Subject: **Review of Plans and Minimal Risk Statements** - Proposed Residence
6221 – 83rd Place Southeast, Mercer Island, Washington

Reference: "Geotechnical Engineering Study," subject site, Geotech Consultants, May 25, 2022

Plans: **Julian Weber Architects** – Sheets A0.0 through A6.3, Dated January 9, 2023.
Malsam Tsang – Sheets S0.0 through S5.0, Dated January 6, 2023.

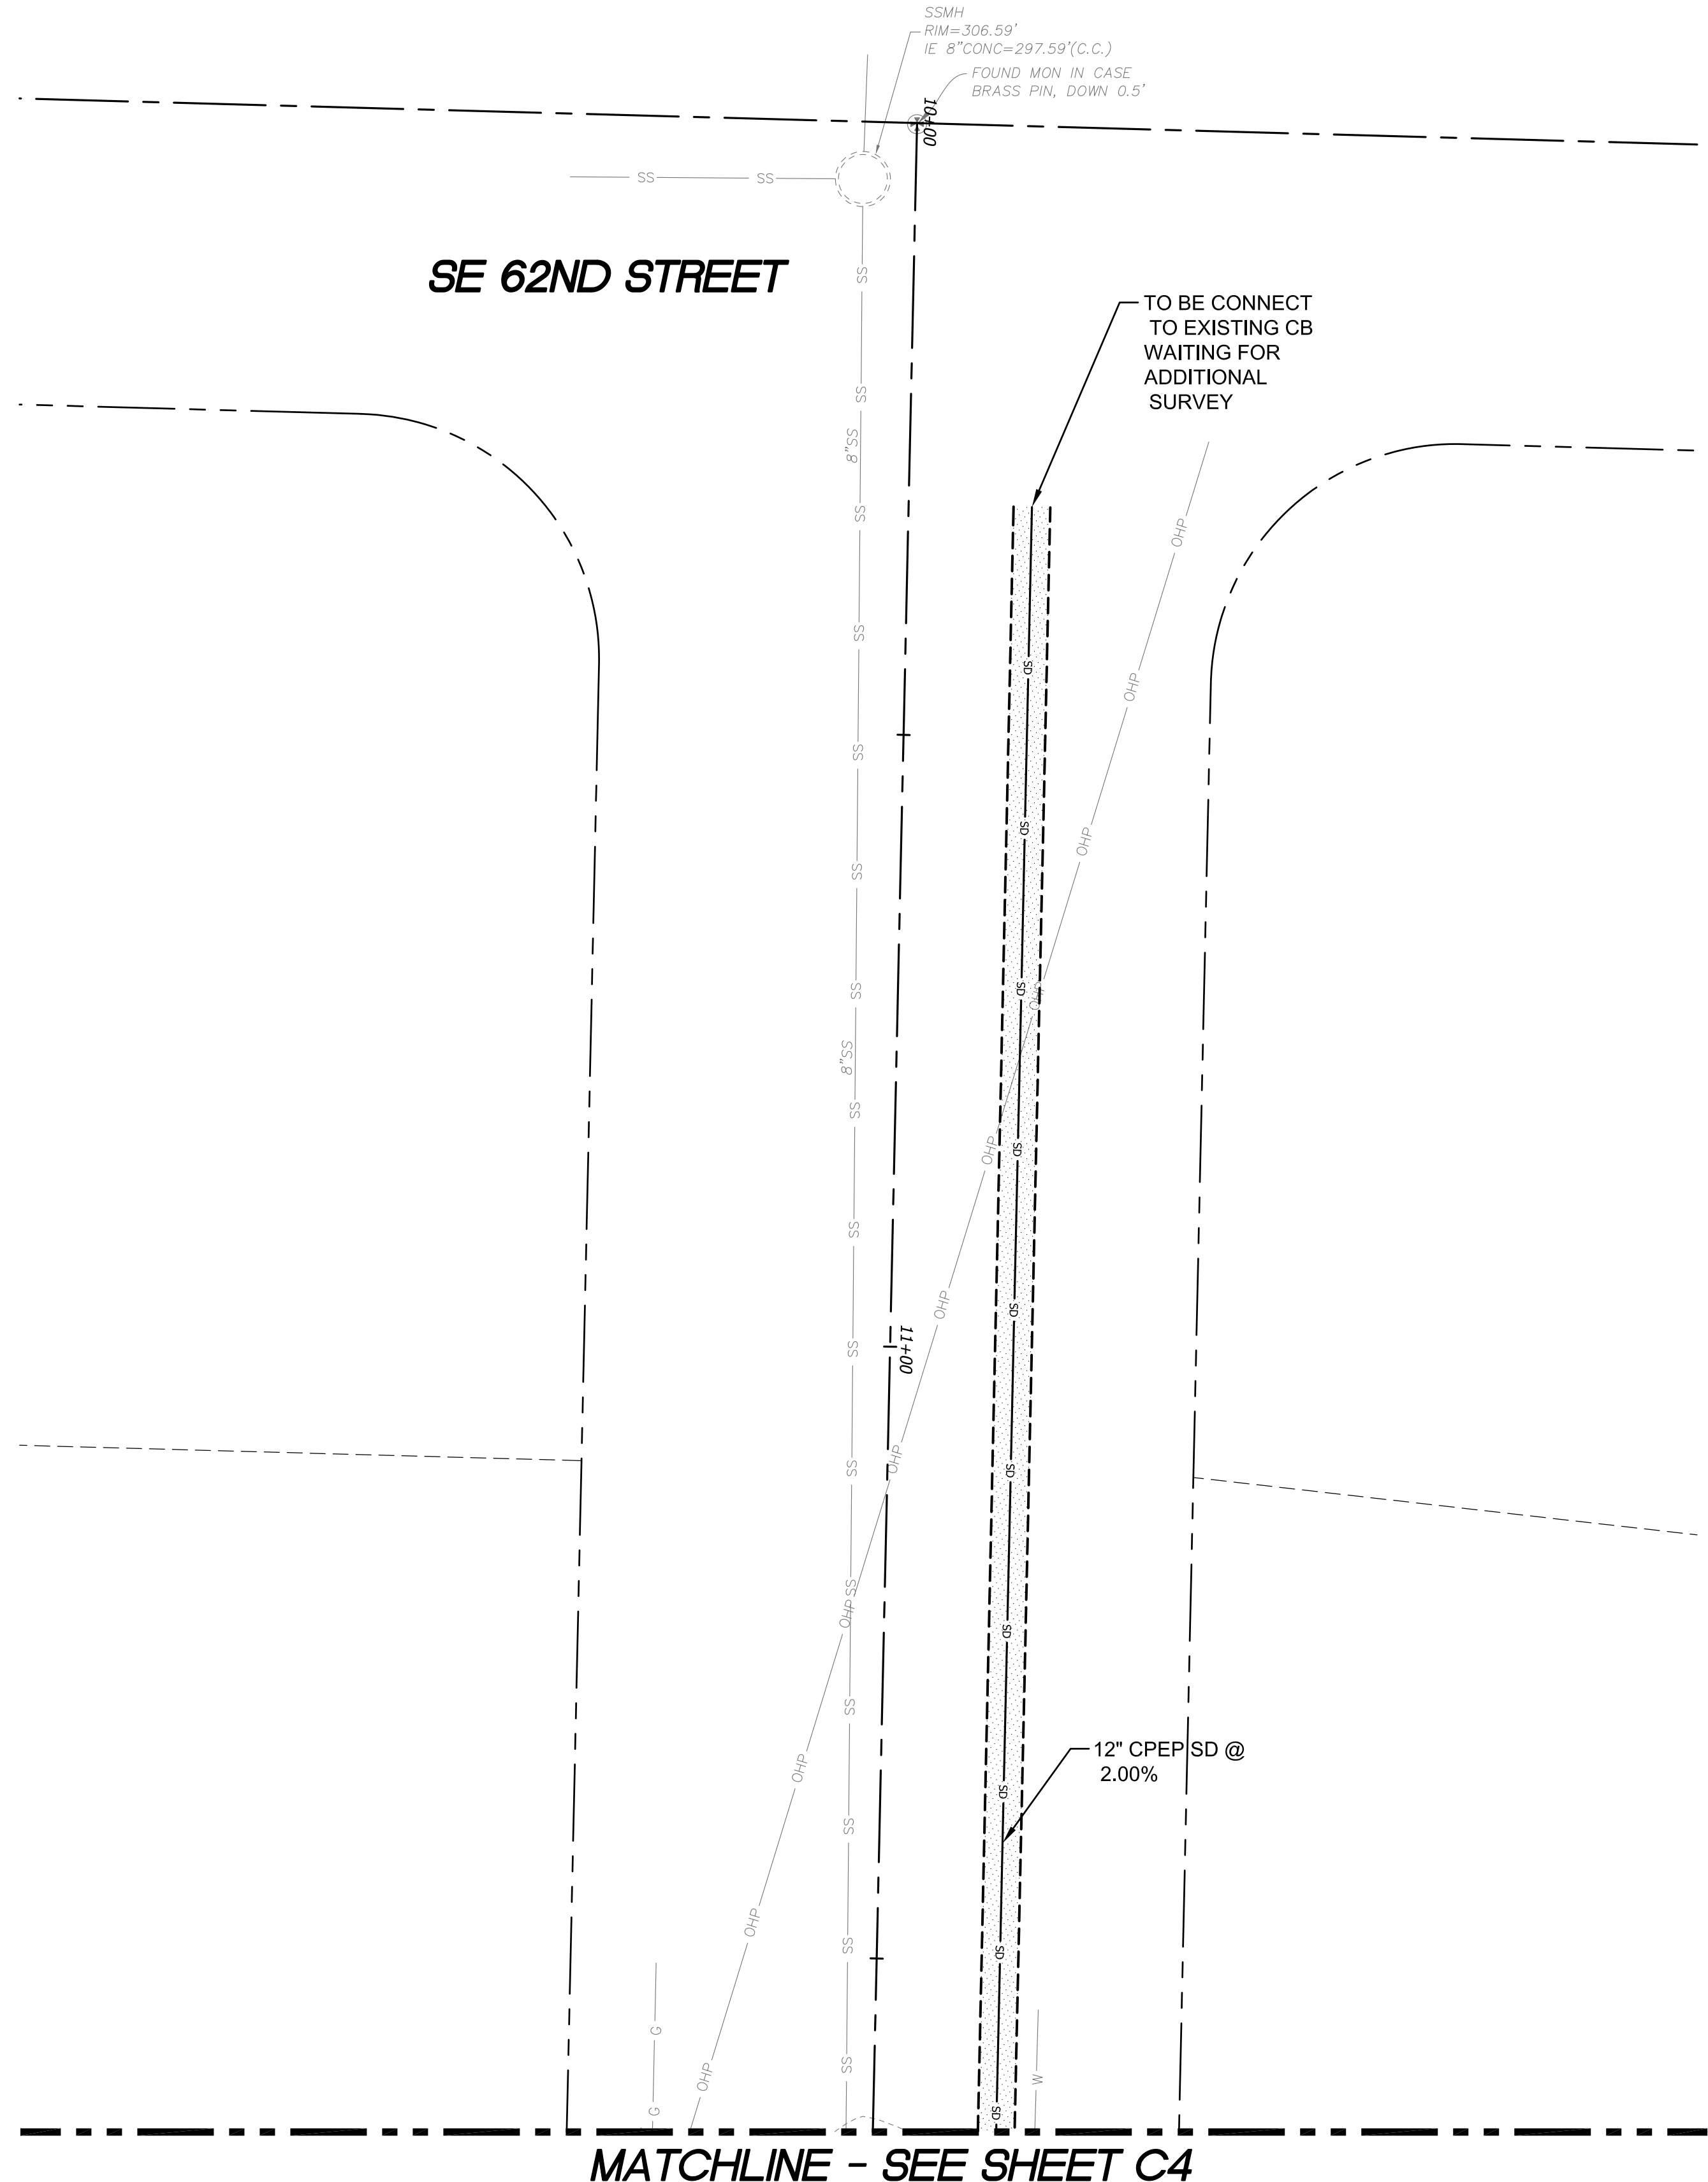
- The dispersal gravel pads shown on the drainage print have limited tributary areas (small patio area that is not overhung by the house and waterproof deck, and the front sidewalk). Also, these areas are over 30 feet from the western 6-foot rockery. As such, these dispersal areas are not a geotechnical concern with the site stability.
- The foundations in the area of the southeastern end of the basement appear to be at a 0.75:1 (H:V) slope from the adjacent property line (~10 foot cut at 7.5 feet from PL). Our test pit TP-1 was in that area of the site and exposed competent native soils at approximately 6 feet below grade. On that basis, it is appropriate to plan on Type A soil conditions in this cut area wherein a 4 foot vertical section may be made at the toe of a 1:1 (H:V) upper slope. We do not anticipate needing shoring in this area of the site.
